**From:** Sutton, Tracy - Oxfordshire County Council <Tracy.Sutton@Oxfordshire.gov.uk>  
**Sent:** 24 October 2023 19:50  
**To:** Planning  
**Cc:** imogen.hopkins@cherwell-dc.gov.uk  
**Subject:** TCPA 1990 Application 23/02716/DISC; Public rights of way Bourton parish footpath 8

Application No.: 23/02716/DISC

**Public rights of way Bourton parish footpath 8 (138/8/10)**

DRWG. N^o. PBA1

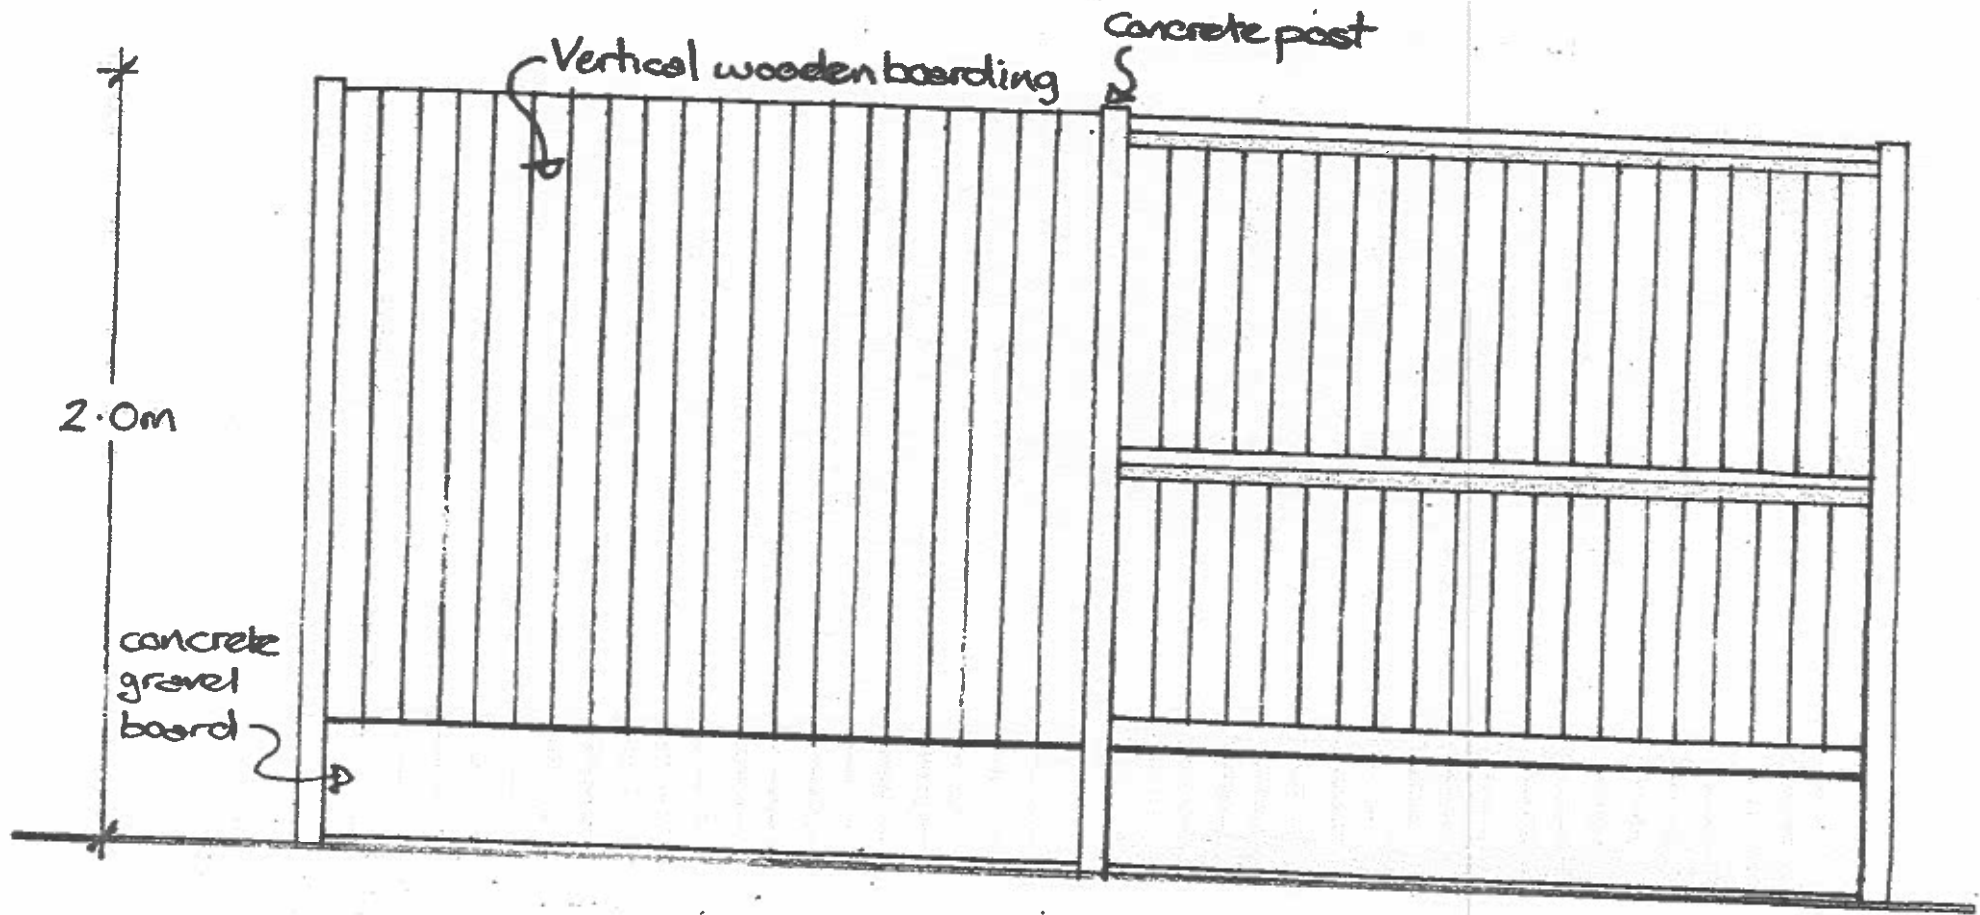
- Figure 1 of the proposed SuDS scheme and PBA1A (2) differ
- A surface water drainage network is shown to cross the footpath on PBA1A (2)
- A swale and surface water drainage system is shown in the immediate vicinity of the footpath on PBA 1

- The plan PBA1A (2) proposes the surface water drainage network to cross the footpath. Please demonstrate how the path will be affected during construction and occupation.
- The SUDS scheme plans (Figure 1) shows the swale and surface water drainage system to be in the immediate vicinity of the footpath. Please demonstrate how the path will be affected during construction and occupation.
